Recommendation Report

AB/107/11

Removal of existing stables and stores and erection of 7No. single storey guest lodges with associated parking and site works.

Priory Farm Cottage 60 Priory Lane Tortington Arundel BN18 0BG

client	Mr & Mrs Thomson	drawing Plan & Elevations Guest Lodge 1	drawn by ASB	date October 2011	rev A
project	Priory Farm Cottage, Arundel

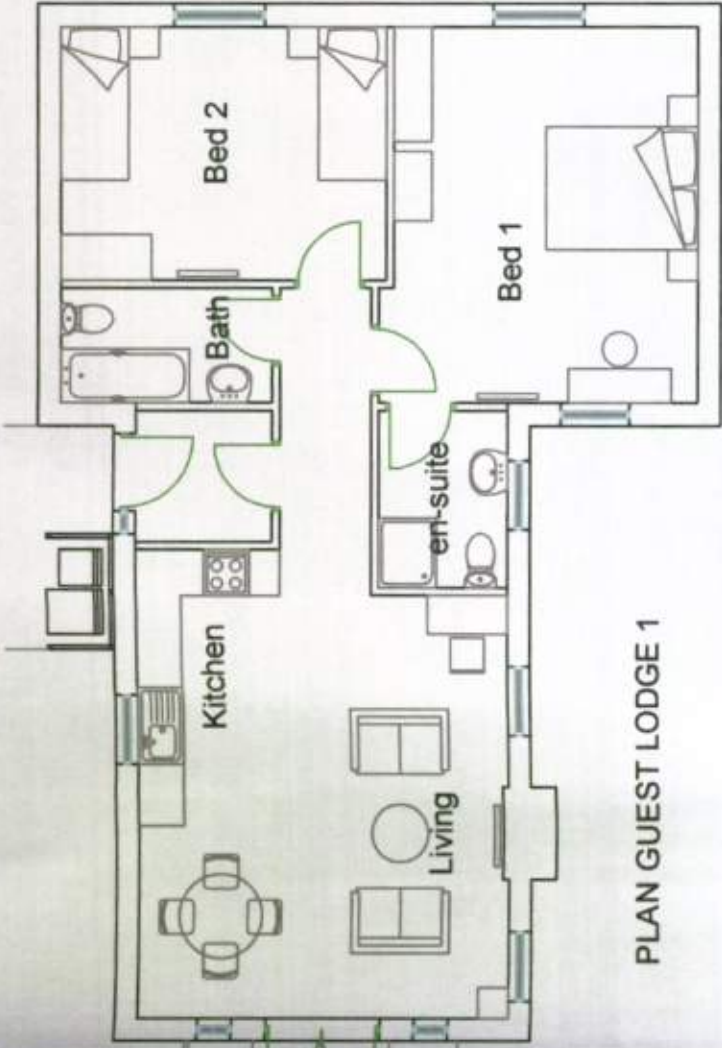
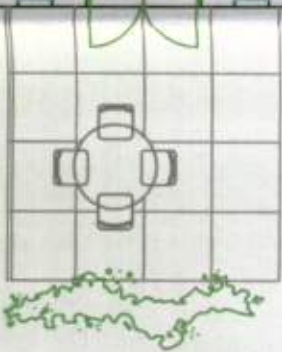
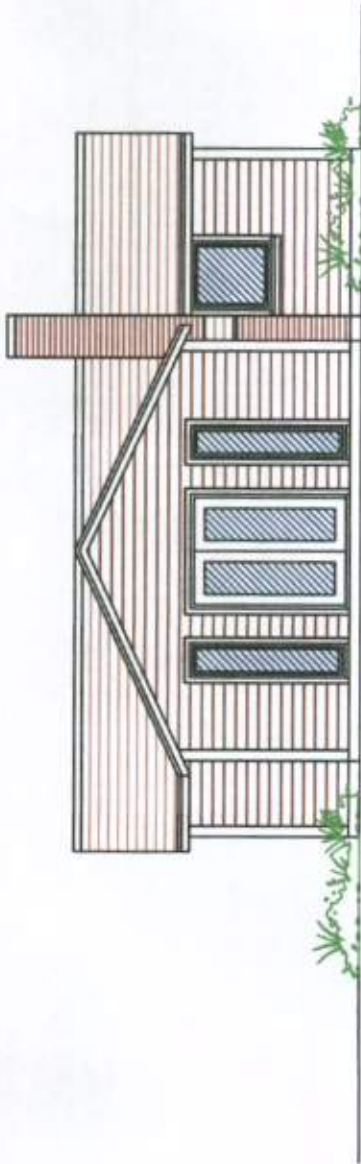
Please submit a Bin Storage/Collection statement or amend the proposed site/block plan to include the details of the bin storage for every holiday lodge.

The Proposed Site Plan A911 /04 rev C now indicates the refuse and recycling facility
for each holiday lodge and the Plan and Elevation for Guest Lodge 1 now illustrates
additional detail of proposed bin storage facilities. Wheeled bins will facilitate easy
collection.
